Our ref: 107016

7 November 2020

SSD 7874 Redevelopment of the Harbourside Shopping Centre Submission on Visual Effects and Impacts of proposed further amended application

/ Axonometric view of the northern podium

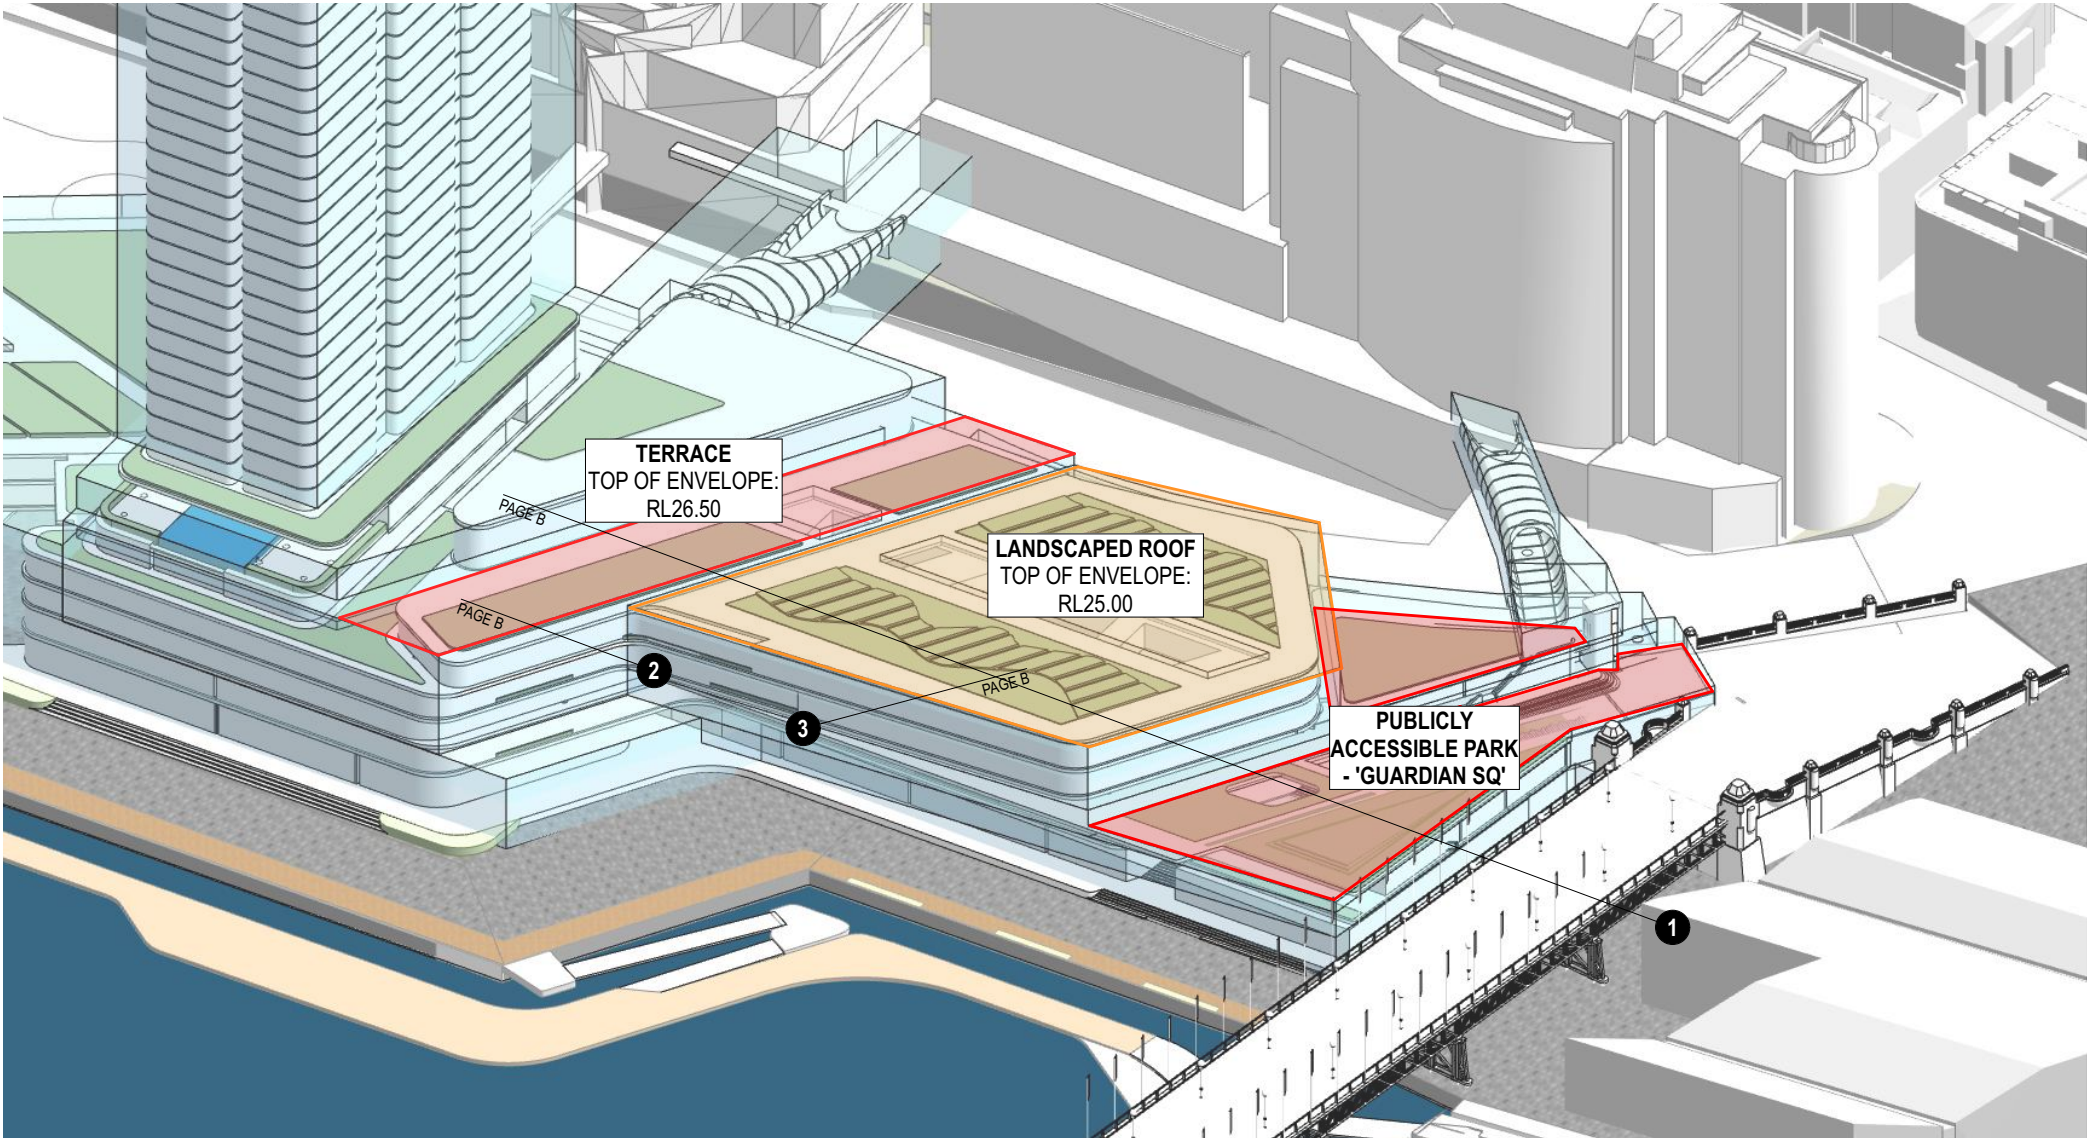
The changes made to the form and height of the podium at the north adjacent to Pyrmont Bridge provides some view improvement for a very small number of low rise apartments in One Darling Harbour. A much larger number of apartments will suffer view loss, up to at least Level 7 on my estimation, that is caused by the height of the proposed podium further to the south of the alignment of the southern edge of the potential plaza space.

The lower podium is an improvement to views from One Darling Harbour that is appreciated, but the benefit should be extended by moving the south boundary of the lowered section of the podium further south and on an alignment more directly easterly, for example to the alignment of the next step in height in the podium that is proposed further to the south.

I have noted the part of the podium that is still of concern with regard to view sharing with One Darling Harbour on Figure 1 below, by means of a transparent yellow fill on a graphic adapted from Image 31 from the FJMT Supplementary Architectural Design Report. The slot in the podium benefits a small number of apartments, whereas the height of the part of the podium shaded yellow causes continuing unreasonable view loss for a much larger number. Reconsideration of the height of this part of the podium could provide a satisfactory outcome for One Darling Harbour in terms of view sharing.

If it is true that the cut out in the northern part of the podium is really intended to foster better view sharing, there is clearly the potential to extend that means of achieving this by cutting the northern extent of the main northern section of the podium further back. There was no loss of GFA involved in making the concessions associated with the Guardian Square podium, so there would seem to be none involved in cutting the height and bulk of the podium back further, to achieve a more equitable view sharing outcome.
